**WELWYN HATFIELD BOROUGH COUNCIL
EXECUTIVE DIRECTOR - PLANNING, PUBLIC PROTECTION AND GOVERNANCE**

DELEGATED APPLICATION

Application No: 6/2020/2581/FULL
Location: Chancellors School Pine Grove Hatfield AL9 7BN
Proposal: Laying of engineered surface for the provision of additional car parking and erection of fencing (Temporary period of three years).
Officer: Mr David Elmore

Recommendation: Granted

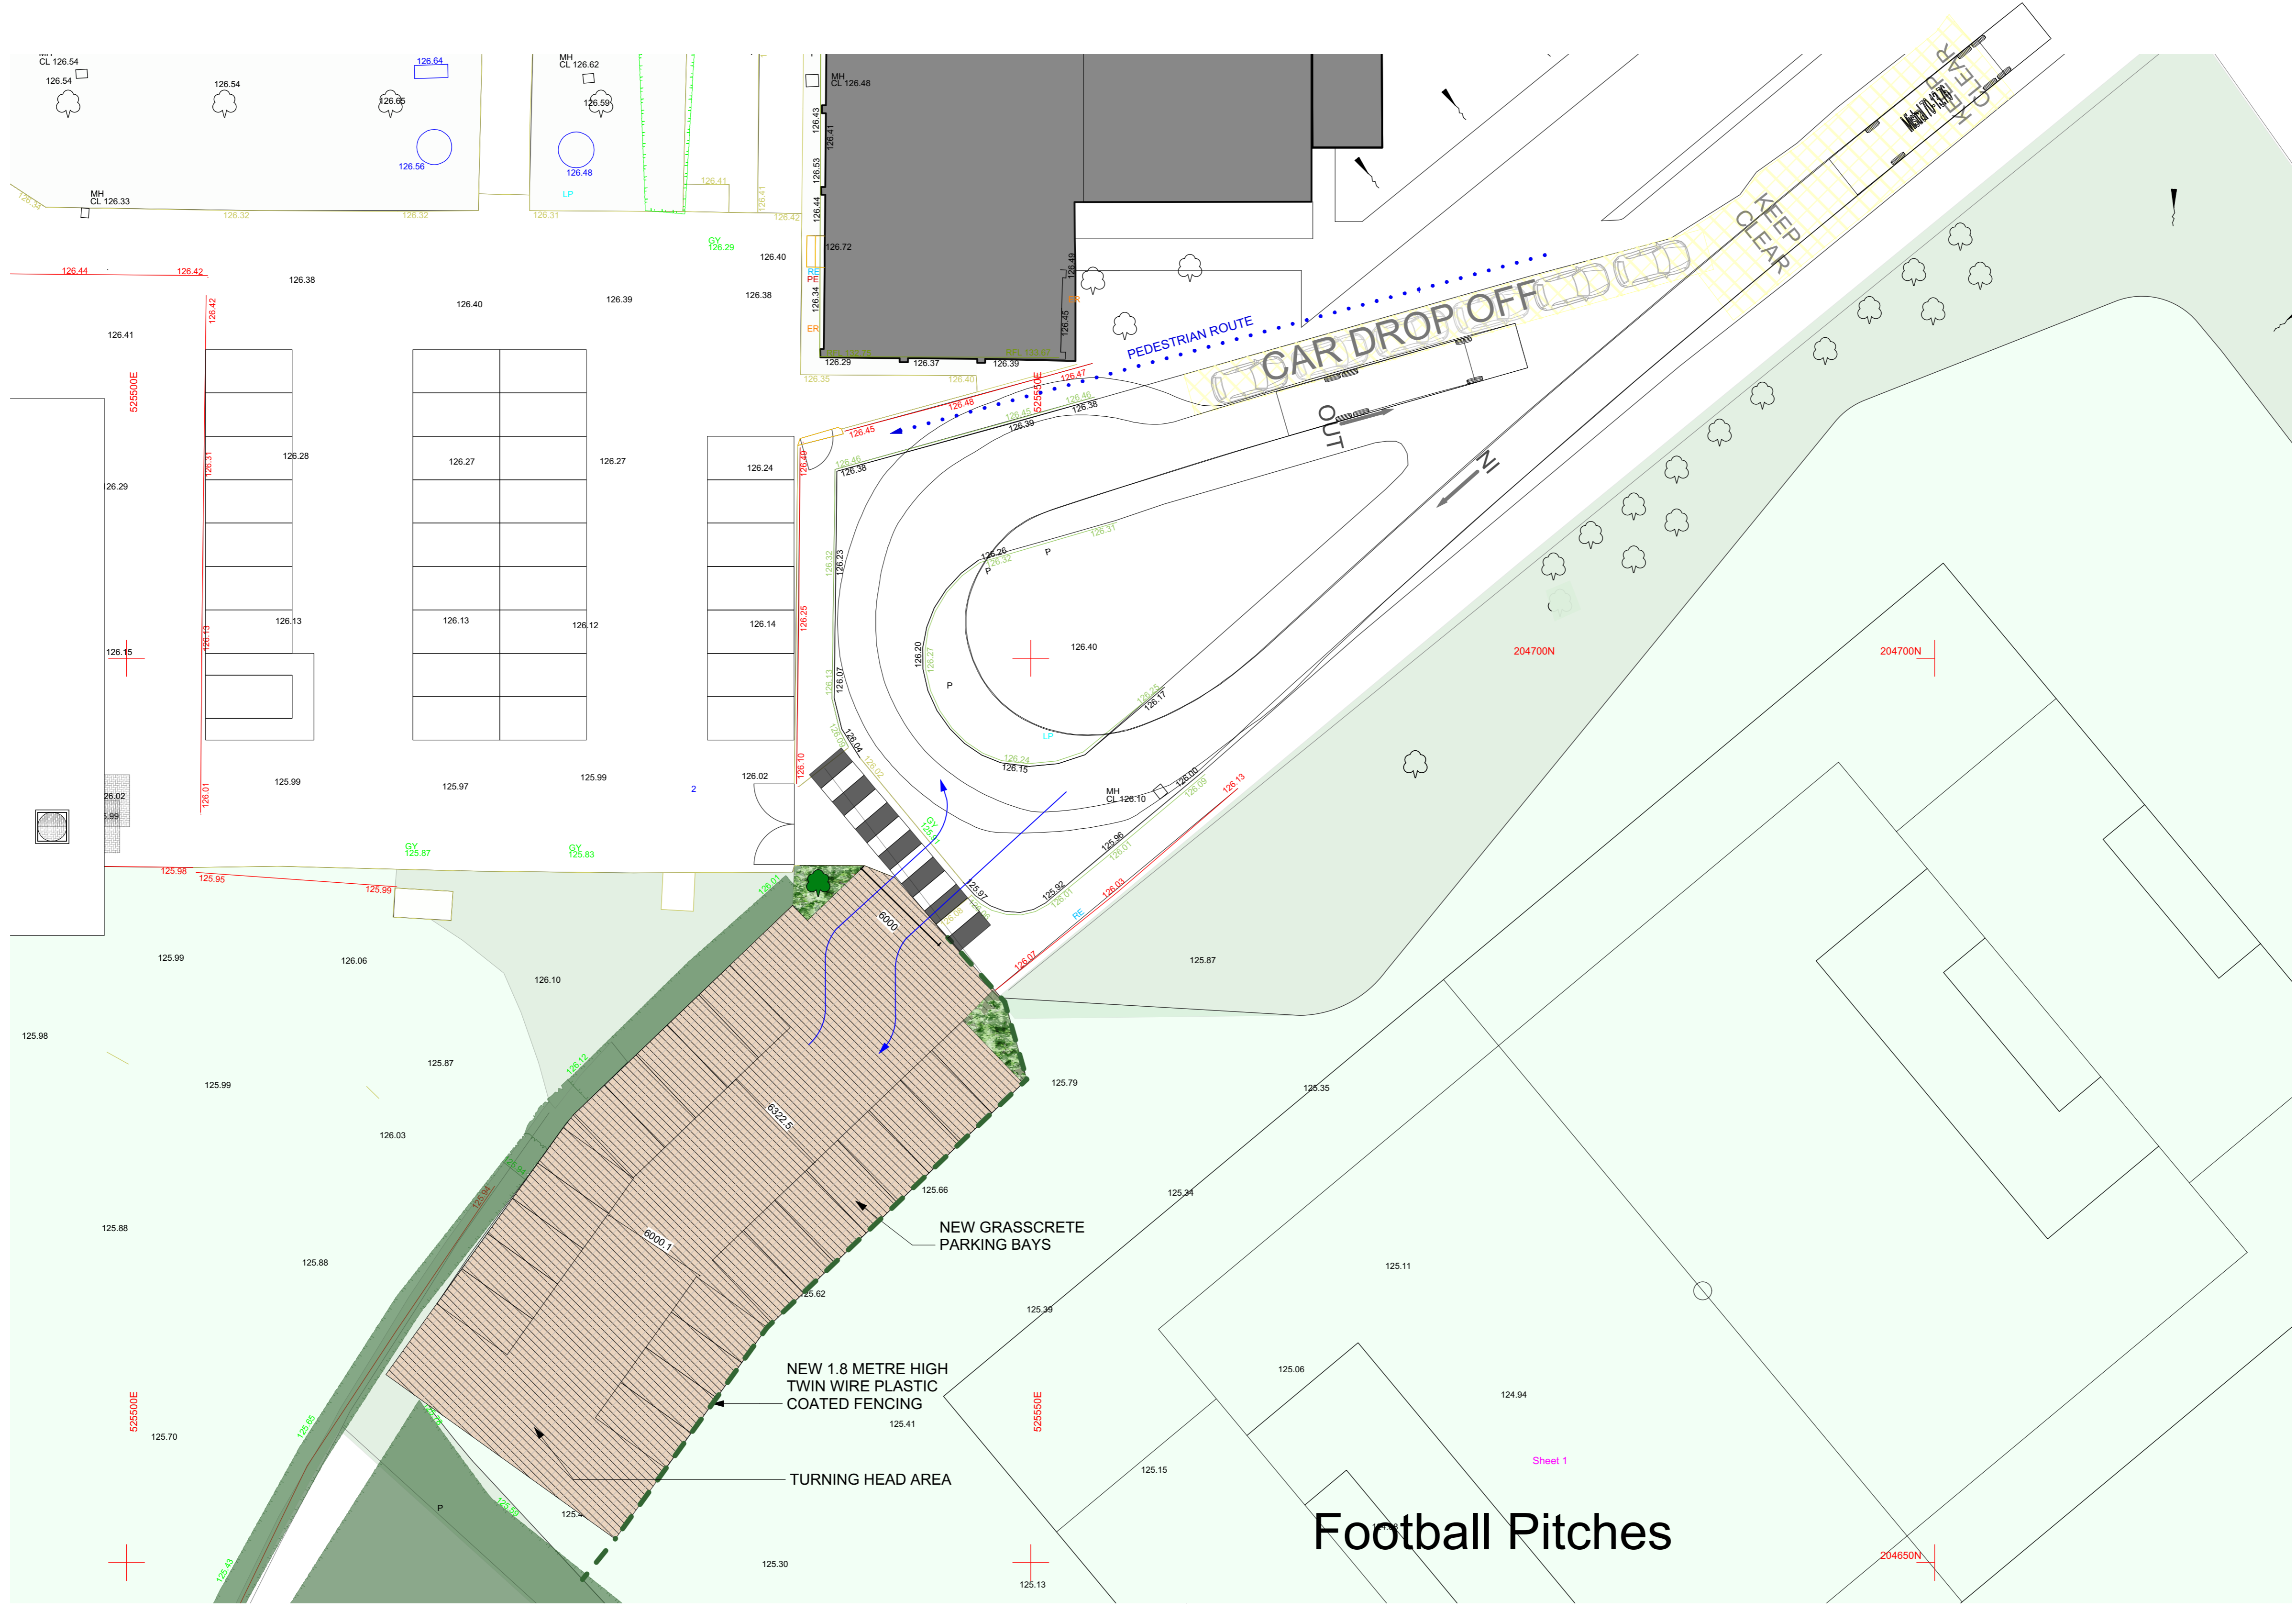
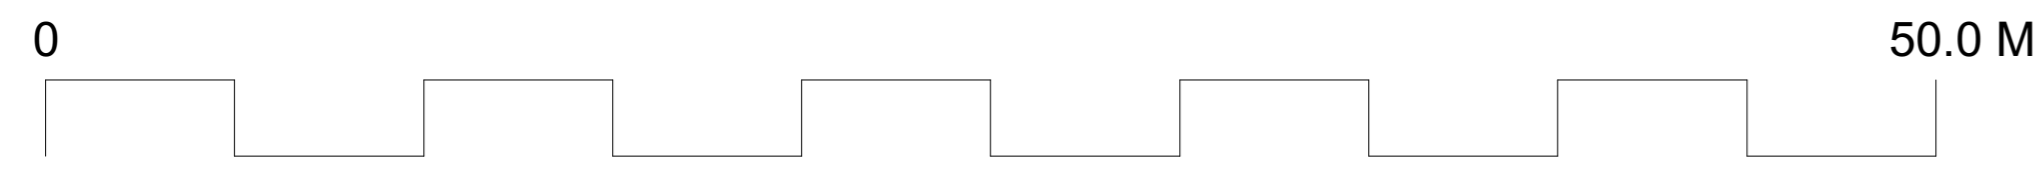
The Highway Authority have been consulted for this application. Following comments from the Highway Authority, it has been necessary to reduce the number of car parking spaces with the proposed parking area to ensure that vehicles can effectively manoeuvre in and out of spaces and exit in a forward gear. This has been reflected in the revised site plan.

The proposed surface would have an approximate width of 16 metres and approximate length of 38.3 metres and accommodate 22 car parking space.

The proposed area for car parking would be considerably larger than the one it would replace. Having regard to its location, footprint and notable increase in available area for car parking, it is considered that the proposed engineered surface would fail to preserve the openness of this part of the Green Belt.

2. Prior to first use of the temporary car parking area hereby approved, its car parking spaces must be laid out and demarcated in accordance with submitted drawing number 2154 5 00 0107 Revision G and be retained in perpetuity with the permission.
